From: Simon Power
Sent: 07 February 2008 11:36
To: Planning.Responses
Cc: Brian Holland
Subject: FW: Planning Consultation on: BE/1/08/

From: Simon Power
Sent: 07 February 2008 10:44
To: Planning.Responses
Cc: Brian Holland
Subject: RE: Planning Consultation on: BE/1/08/

APPLICATION NO:	BE/1/08/
Registered:	07-JAN-08
Site Address:	Land at Oldlands Farm Shripney Road Bognor Regis
Grid Reference:	494300-101410
Category:	Plan Applicat'n
Description of Works:	Outline application for mixed use employment (Class B1 high quality business park comprising up to 19,500 SQM gross floorspace) and retail (Class A1 grocery store up to 4,459 SQM net sales area) together with parking, new highway & associated servicing, infrastructure & landscaping - This application is a departure from the development plan and is accompanied by an environmental statement

TITLE
Oldlands Farm Business Park
Bognor Regis
Parameters Assesment Plan

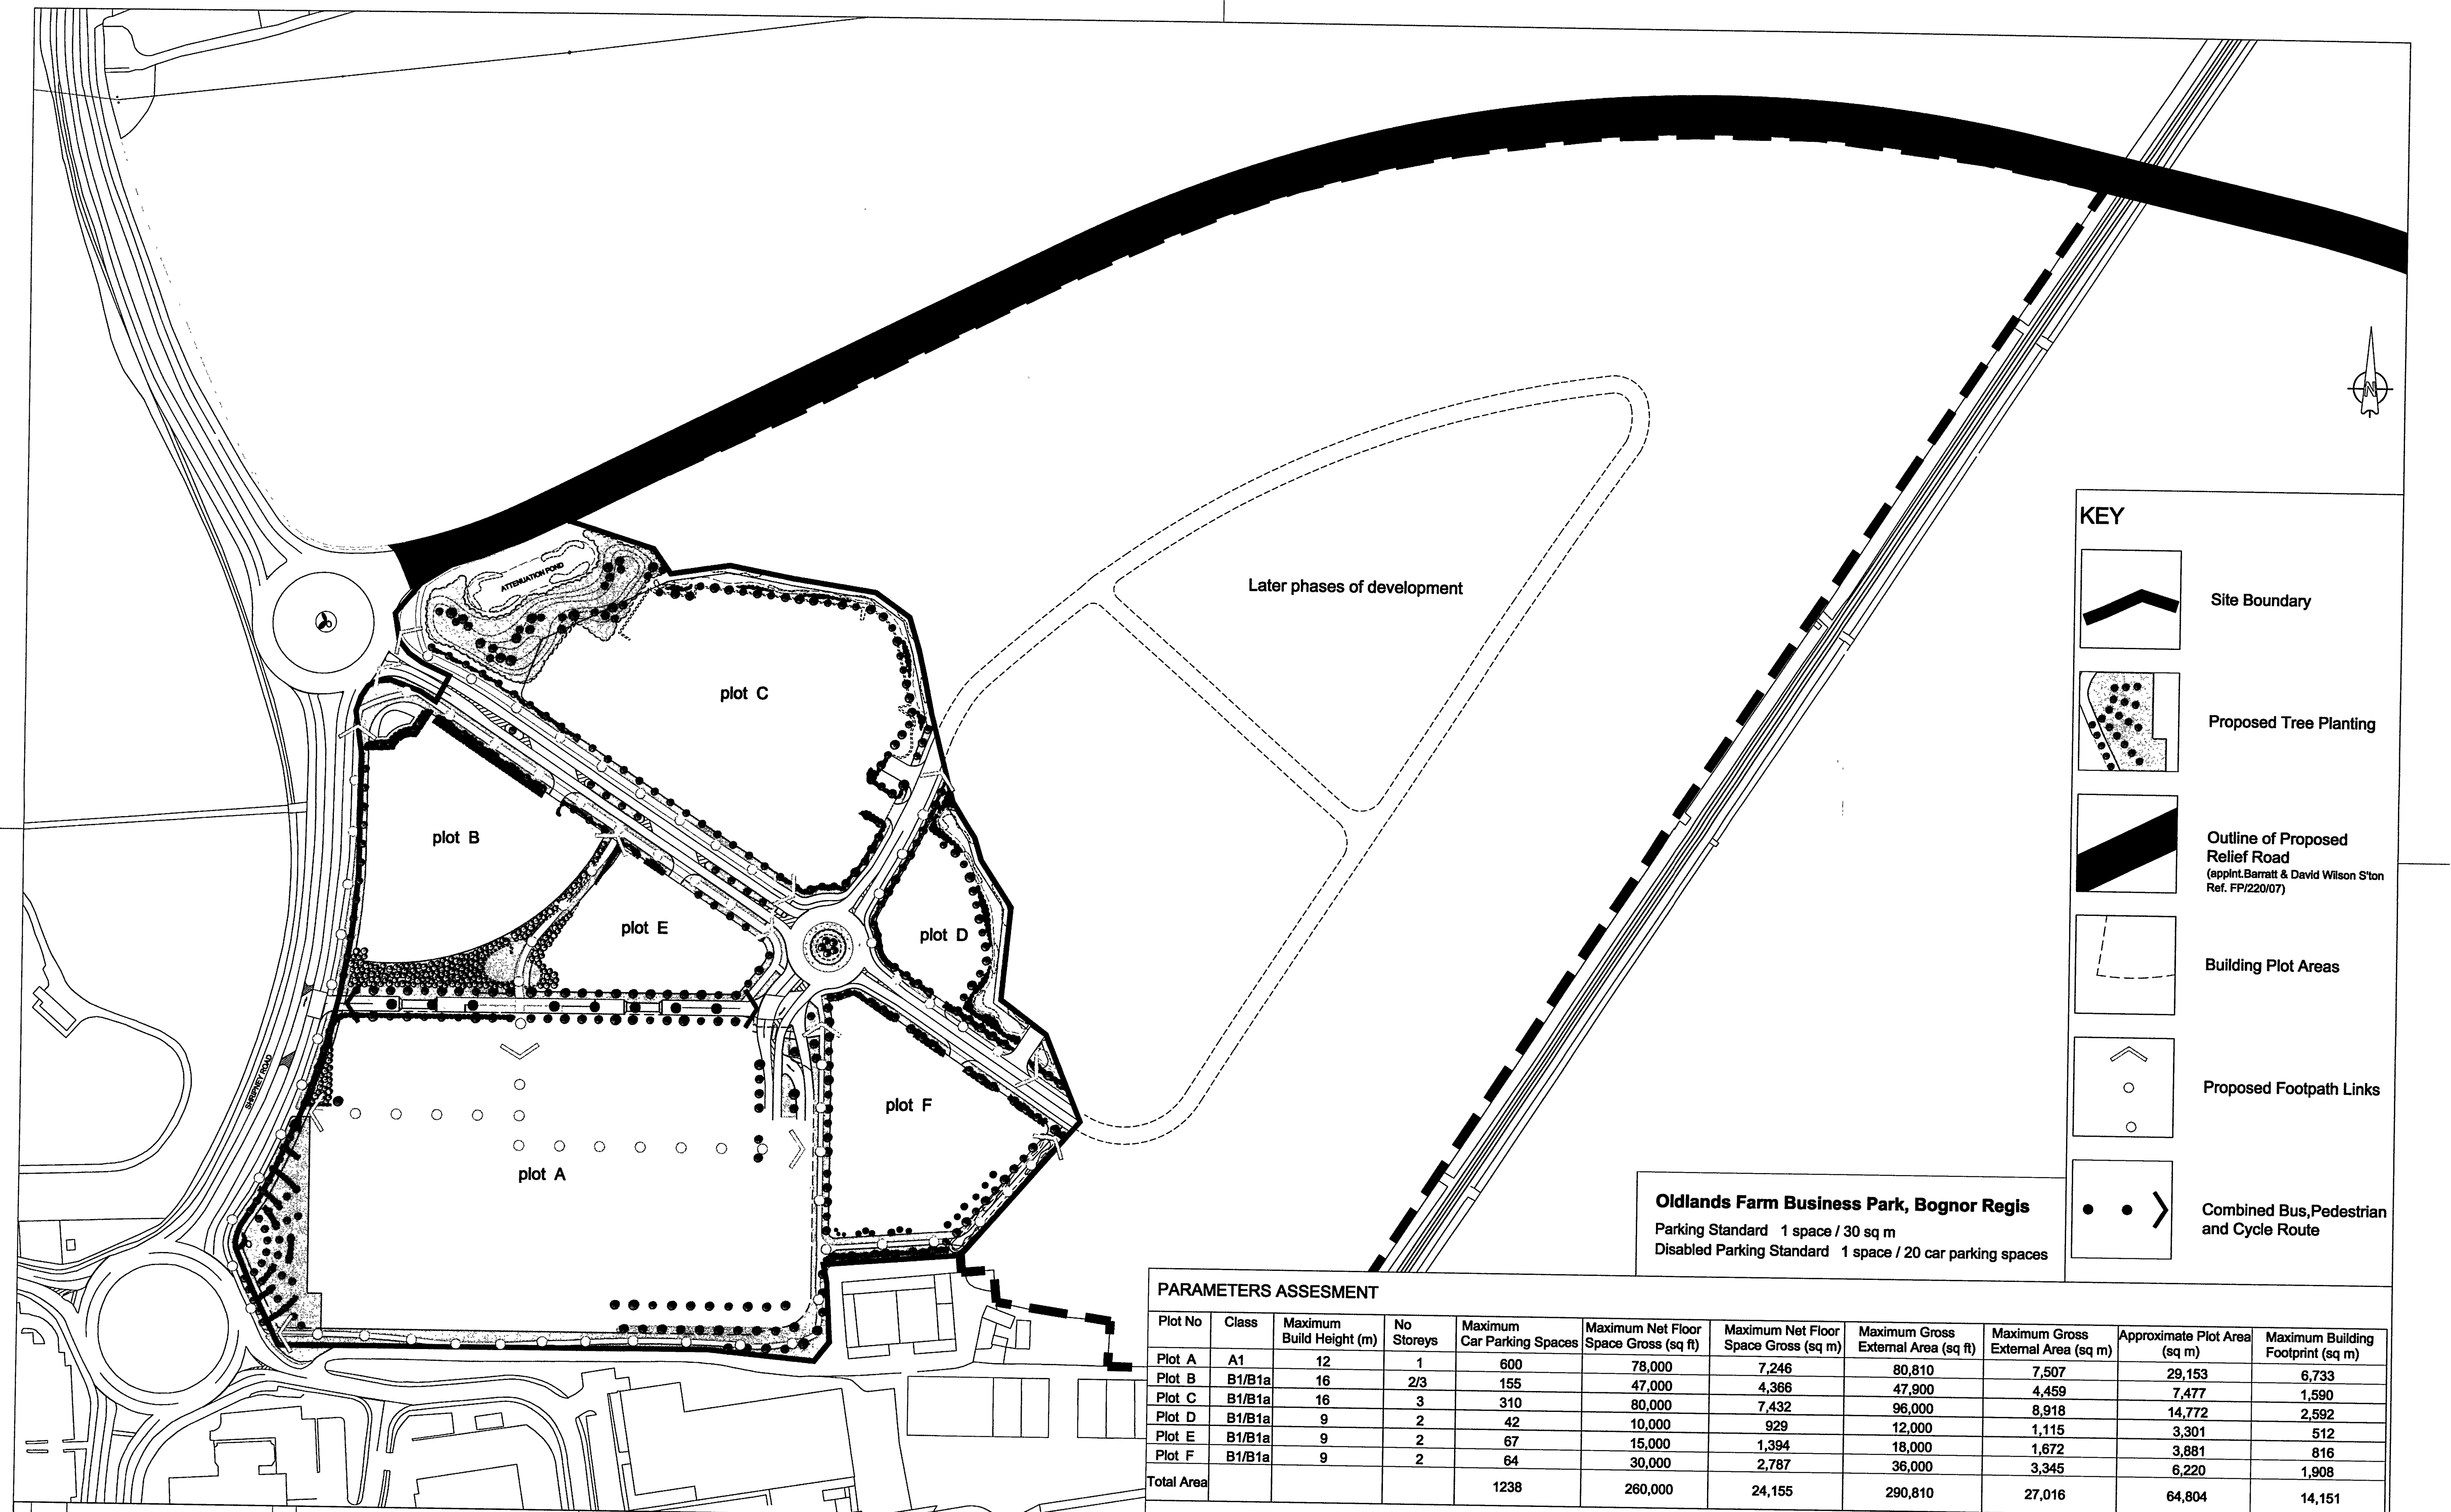
- Twelve months of groundwater table monitoring will be required, at several locations within the route of the proposed storage ditch. This data is required to determine the highest annual level of the groundwater table. The groundwater table is known to exist at a shallow depth within the site. It will be necessary to design the base of the proposed storage ditch, above the highest recorded groundwater table, and to include a safe margin between the groundwater table and base of the proposed storage ditch. This is to ensure that the designed storage capacity of the ditch, will not be occupied by a high groundwater table at any time, taking up some of the storage capacity at the time when it most needed.
